Rezoning Transportation Analysis

Petition Number: 2022-130

General Location Identifier: 20924110

Date	Description
12-28-22	First Review (IW)
02-22-23	Second Review (IW)
04-25-23	Third Review ZC (IW)

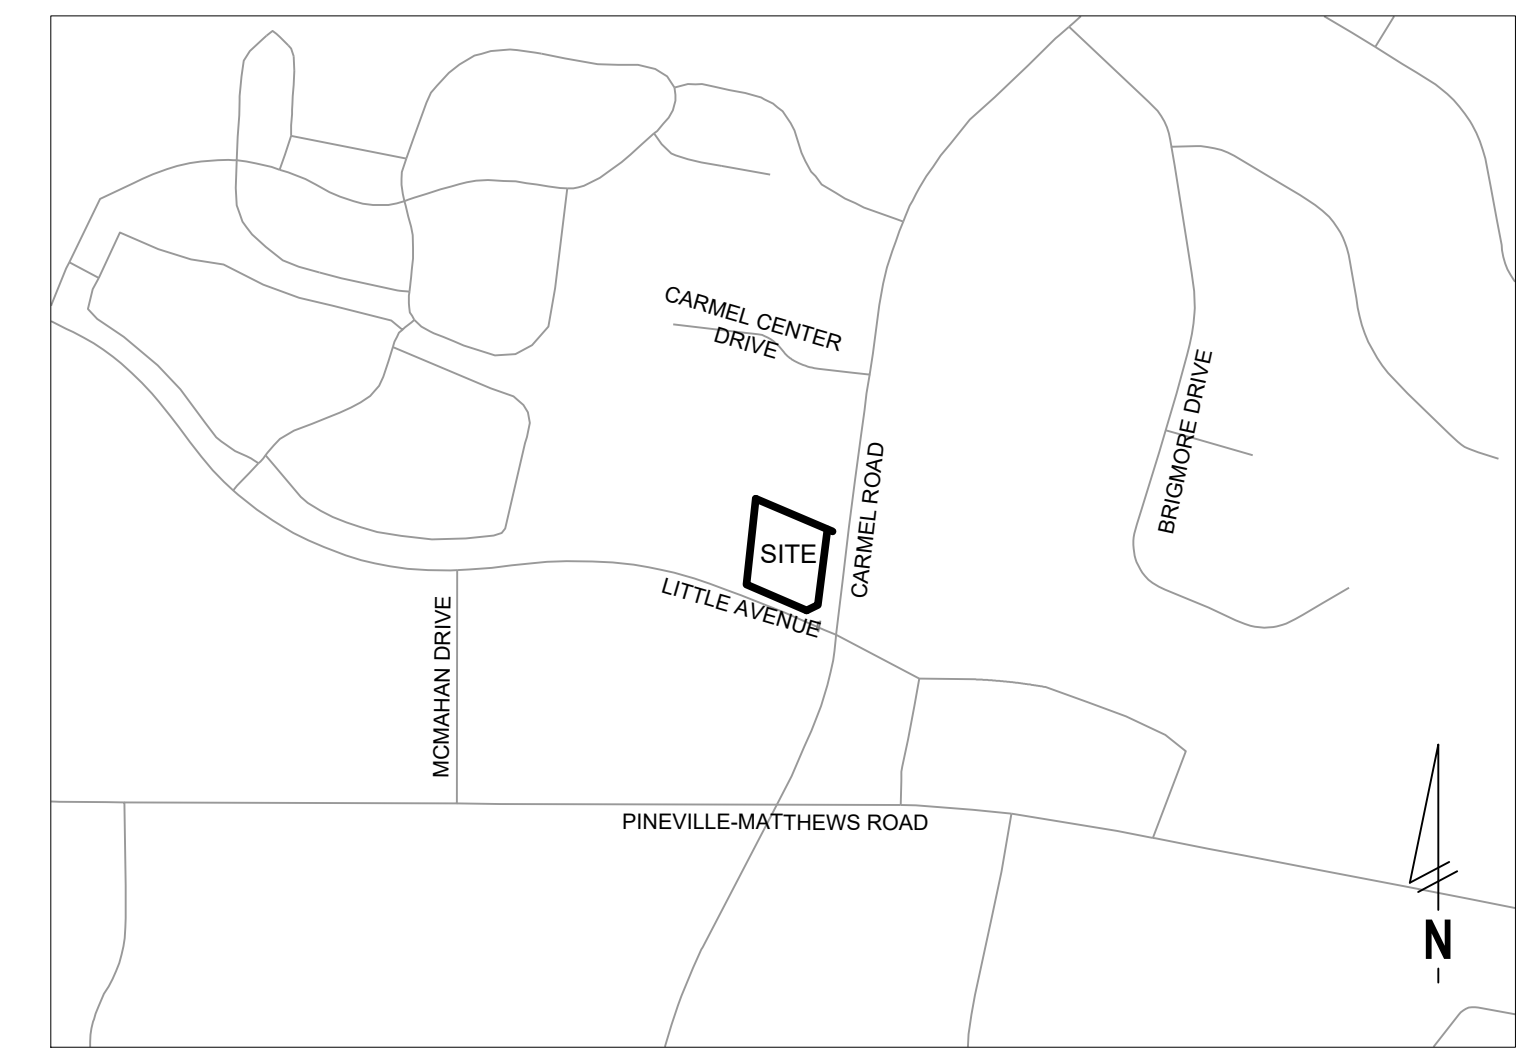
~~1. **Outstanding Comment from 12-28-22 Curbline:**~~

~~a. **Carmel Road:** Location of back of curb and gutter to be moved to 33 feet from roadway centerline to accommodate the Charlotte Streets Map with a roadway typical section of CLDSM 11.09 Major Thoroughfare.~~

~~**Clarifying Note 2-22-23:** Site plan is currently showing 32' from centerline, this should be updated to show the future curb line being 33' from centerline.~~

~~Label and dimension the curb and gutter from the centerline for each road on the site plan.~~

~~3. **Revise site plan and conditional note(s) to commit to dedicate 55' right of way from the road centerline on Carmel Road. The site plan shall label and dimension the right of way from the road centerline.**~~

~~4. **Revise site plan and conditional note(s) to commit to construct an 8-foot planting strip, and 12-foot Multi-Use Path on Carmel Road per the council adopted Charlotte Streets Map. The site plan shall label and dimension both items from the back of curb and gutter or edge of pavement.**~~
